Item No. **Report of the Interim Director of Planning, Regeneration & Public Realm**

Address: 14 DEVON WAY HILLINGDON

Development: Change of use from C4 house in multiple occupancy (HMO) to sui generis HMO for 7 bed and 7 persons with no external alterations.

LBH Ref Nos: 27994/APP/2021/3581

SITE PLAN (1:500)

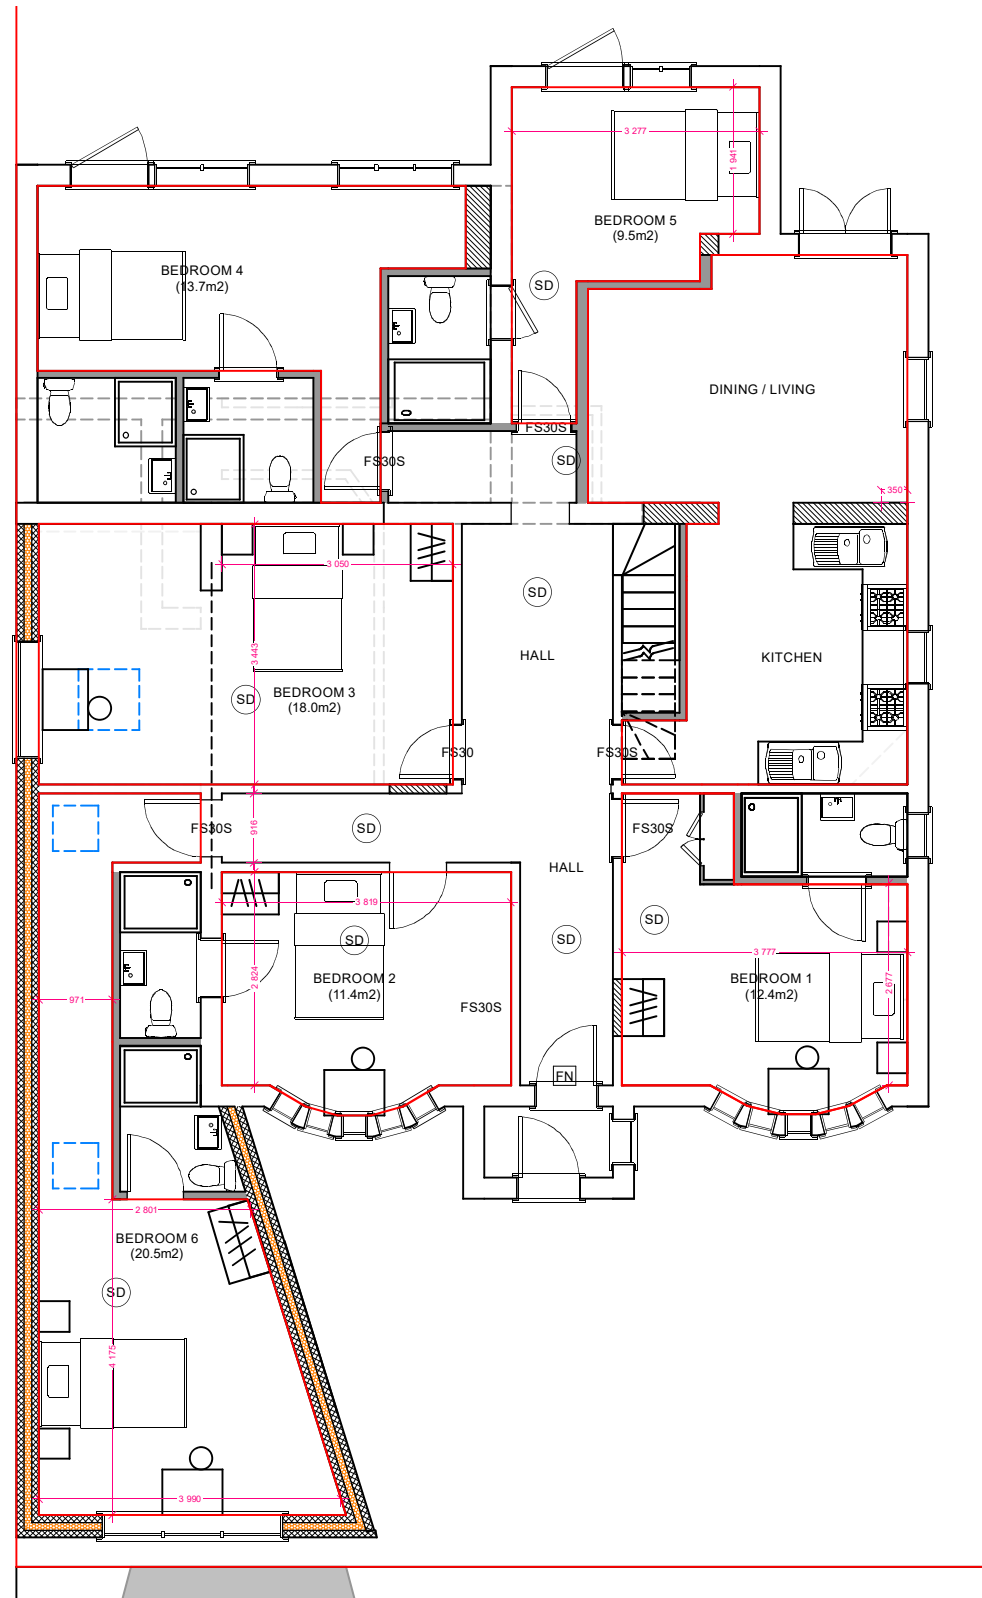
- Submitted plans are incorrect as there is not four on-site car parking spaces (in reality there is only

The application site benefits from a front forecourt that can accommodate 2 vehicles. On-street parking in the vicinity of the site is regulated through single yellow lines a residents' parking permit scheme (HN1). Due regard has been given to the former use of the property as small HMO accommodating up to six persons. However, in the absence of a signed legal agreement to prohibit occupiers from obtaining street parking permits, it is considered that the existing large HMO accommodation coupled with the self-contained residential unit within the outbuilding, would likely park their vehicles on the nearby roads. The site has a PTAL rating of 2 (Poor) which means it is likely that occupiers of the site would be reliant on private vehicles as a means of transport. Thereby, exacerbating the pressure for street parking. A parking impact assessment has not been submitted to demonstrate that the street parking spaces on nearby surrounding roads has sufficient capacity to accommodate the additional parking demand generated by the development. Thus, leading to increased instances of dangerous or illegal parking. This in turn, would result in congestion and prejudice highway safety.

PROPOSED G/F (1:100)

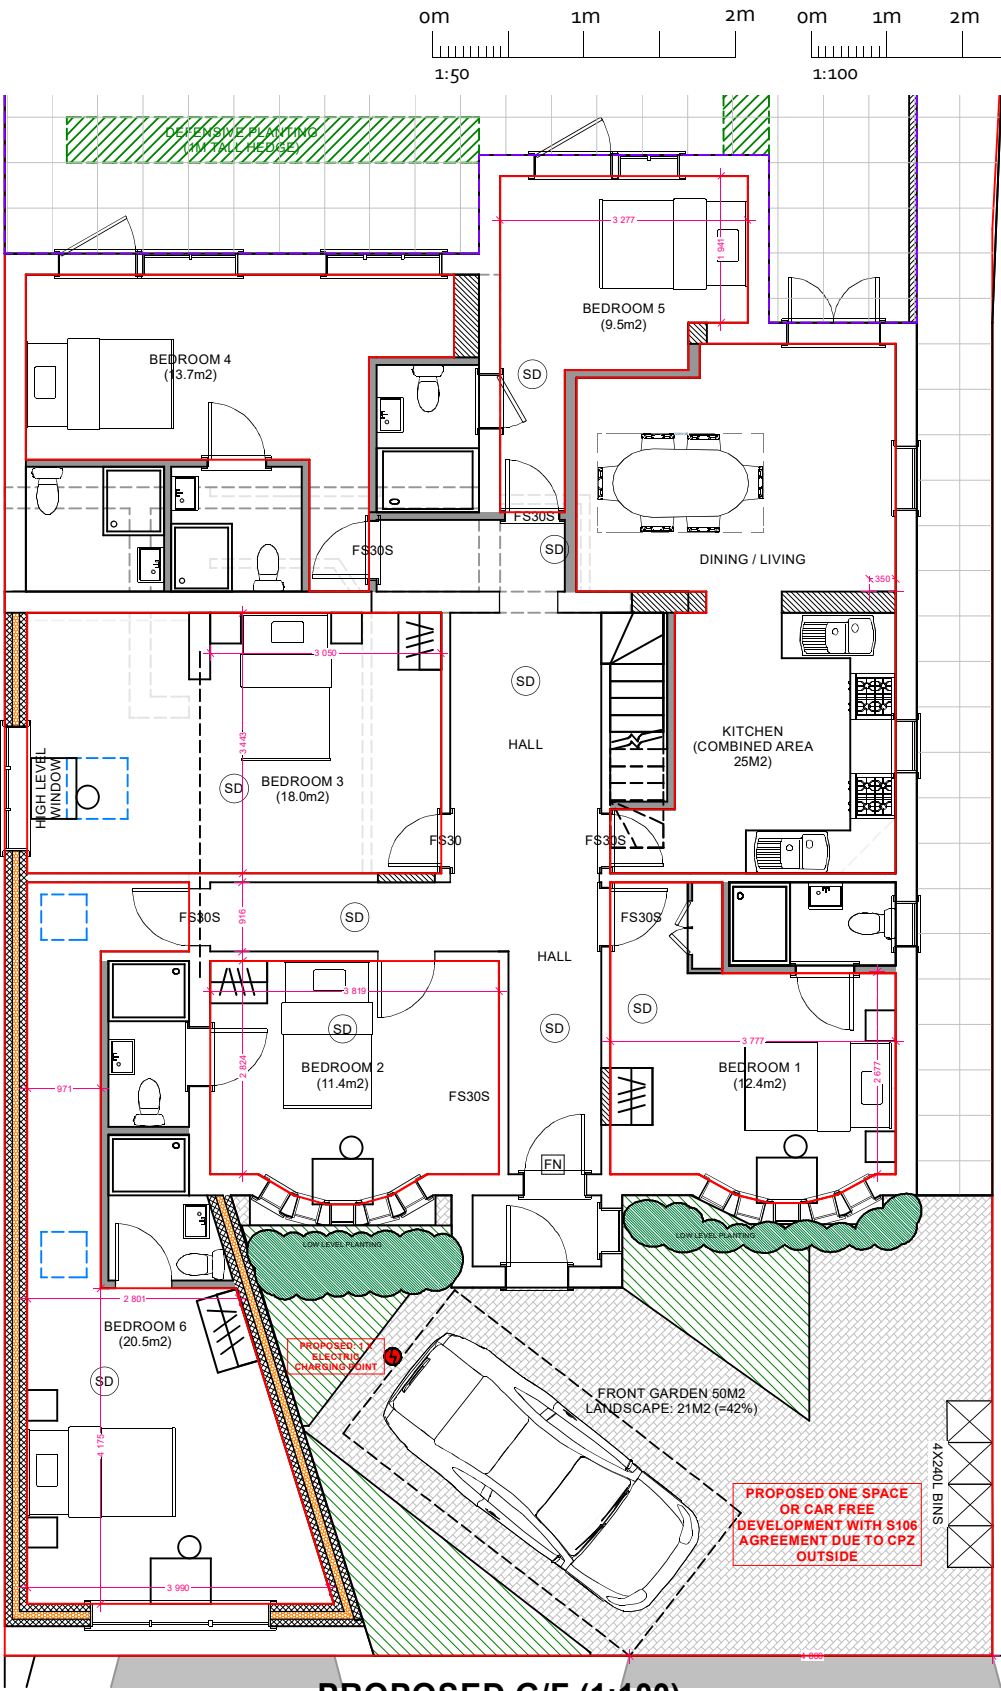
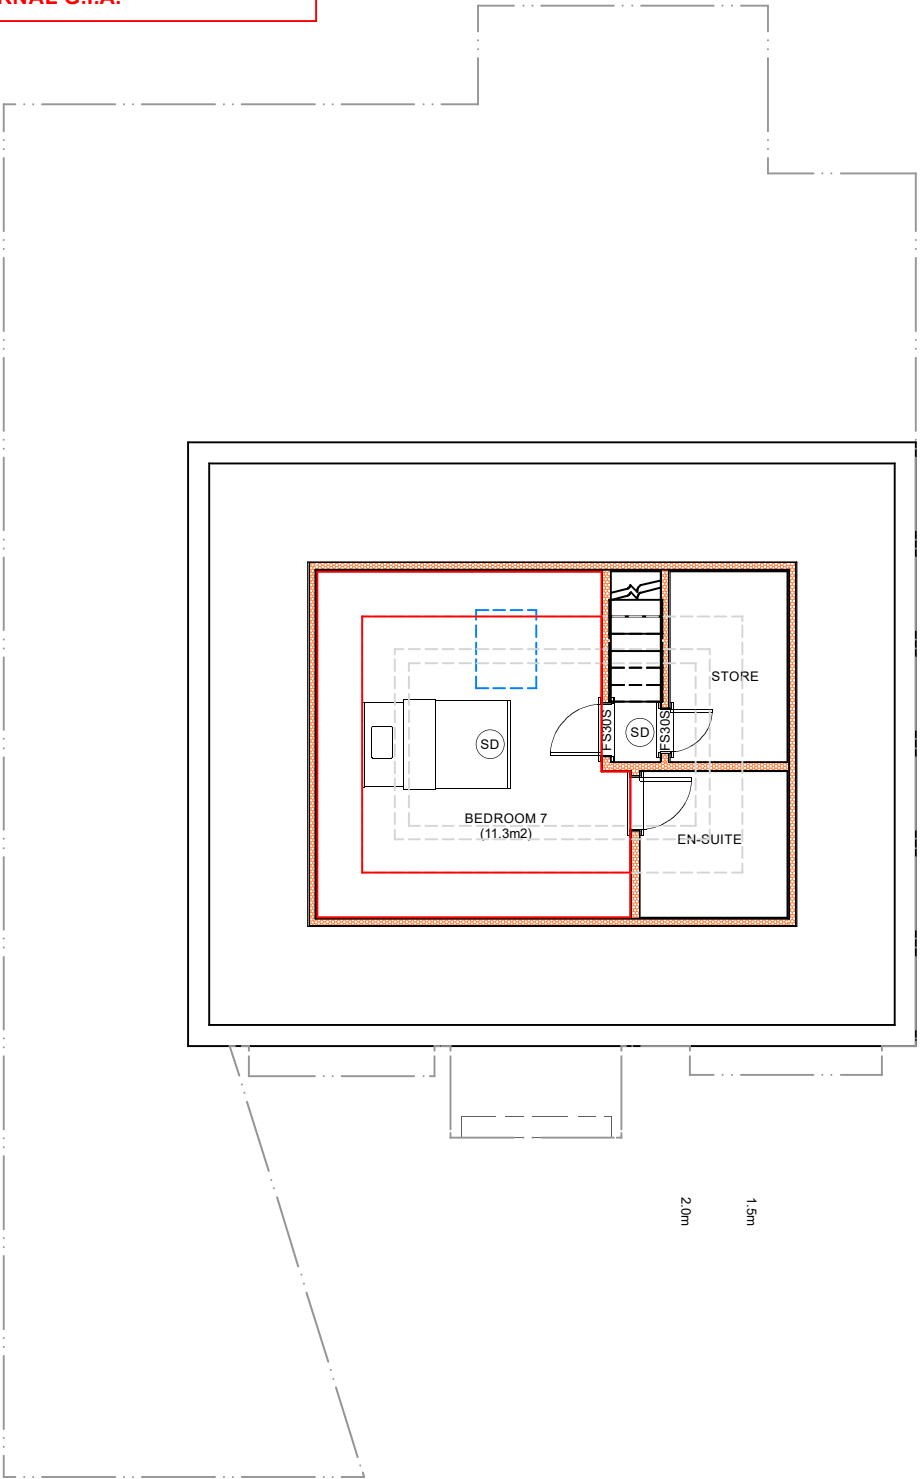
Each of the 7 HMO of the bedrooms benefits from their own en-suite shower rooms and a kitchen cabinet with no sink. During the officer site visit it was observed that none of the 7 rooms contain any cooking facilities (or microwaves). The submitted plans shows a communal kitchen and dining room area on ground floor level, and this was confirmed during the site visit. Having regard to the 'Gravesham' Court Judgement, it is considered that the rooms do not constitute as a self-contained units and that the use of the main property is a large HMO (Sui Generis).

It is acknowledged that the Hillingdon Local Plan: Part 2 - Development Management Policies (2020) does not contain any specific standards in respect to HMO. The submitted plans show that the seven bedrooms which are each occupied by a single person range between 9.5 sqm and 20.5 sqm, which is considered to be acceptable when compared to the bedroom standards prescribed in parts 3 and 4 of Policy D6 of the London Plan. The kitchen/dining/living room has a floor area of 25 sqm which is considered to be of a sufficient size to meet the needs of the seven occupants.

Although Bedrooms 3 and 7 have limited outlook, this is considered, on balance, to be acceptable having regard to the former use of the property as a small HMO. Similarly, the relationship between the windows serving Bedrooms 4 and 5 and the communal garden would not be significantly different to former use of the property as a small HMO. With an area of 135 sqm, the communal rear garden for the occupiers of the HMO is considered to provide an adequate provision of external amenity space.

ANNEX - R/O 14 DEVON WAY

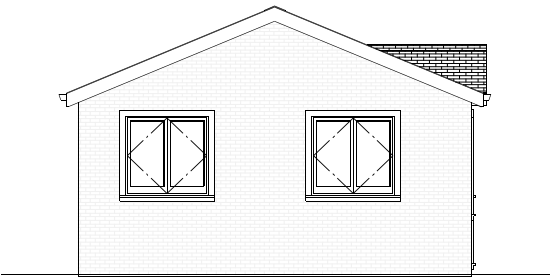
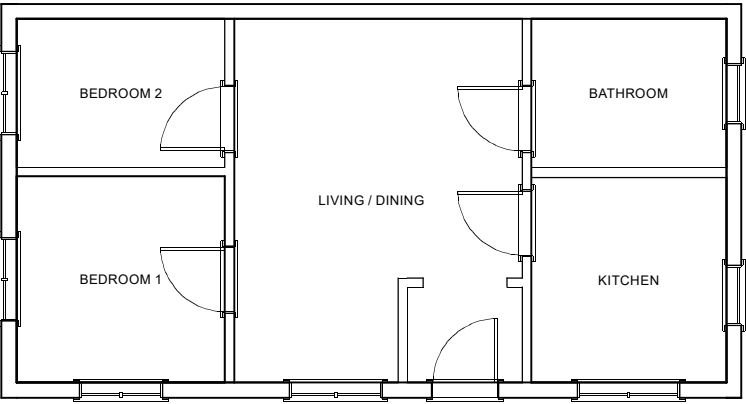
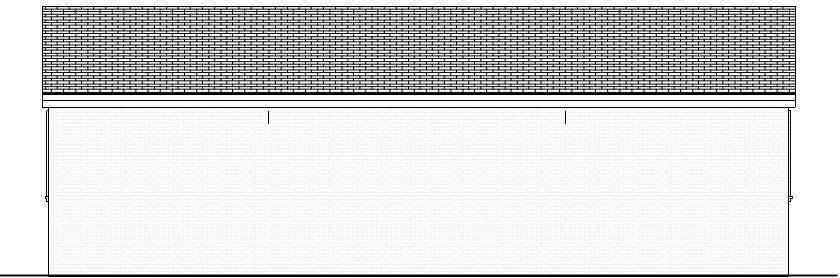
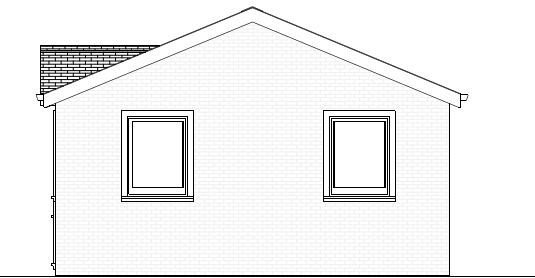
In this case, the existing brick built outbuilding at the site contains a kitchen with a sink, oven and stove; an open plan living/dining room; a shower room with a toilet and hand basin; and two bedrooms. It is therefore considered that the outbuilding has all the day-to-day facilities for it to be used as a self-contained residential unit. There is independent access to the outbuilding through the side passageway. Furthermore, the outbuilding has been sectioned off from the main property by the erection of timber fencing running along its front elevation. Given these circumstances, it is considered that the outbuilding is a self-contained residential unit and as such a separate planning unit has been created.

The rear outbuilding has a gross internal area of 45 square metres, which falls significantly below the London Plan's minimum 61 sqm requirement for a 2 bedroom, 3 person dwelling. Given the figures in Table 3.1 of the London Plan are minimum standards which are intended to act as a benchmark for high quality design, the shortfall in the internal floor space provision is not appropriate. The front elevation habitable windows face directly towards fencing measuring 1.8metres, which is positioned 1 metre away. The side windows serving the bedrooms within the outbuilding face directly towards the side boundary treatment. It is therefore considered that outbuilding provides unsatisfactory living conditions for its occupiers, in terms of inadequate floor space and poor outlook. It cannot be argued that the existing fencing could be removed as this would give rise to a loss of privacy and overlooking issues between the occupiers of the outbuilding and HMO (which contains habitable windows within its rear elevations)

There is a small section of hardstanding adjacent to the northern flank wall of the outbuilding. However, this area is not considered to constitute as private useable amenity space as its covered in hardstanding and adjoins the side passageway leading to the rear garden of the HMO. Consequently, the outbuilding has no external amenity space provision, which conflicts with the minimum 60 square metre requirement found in Table 5.3 of the Hillingdon Local Plan (Part 2).
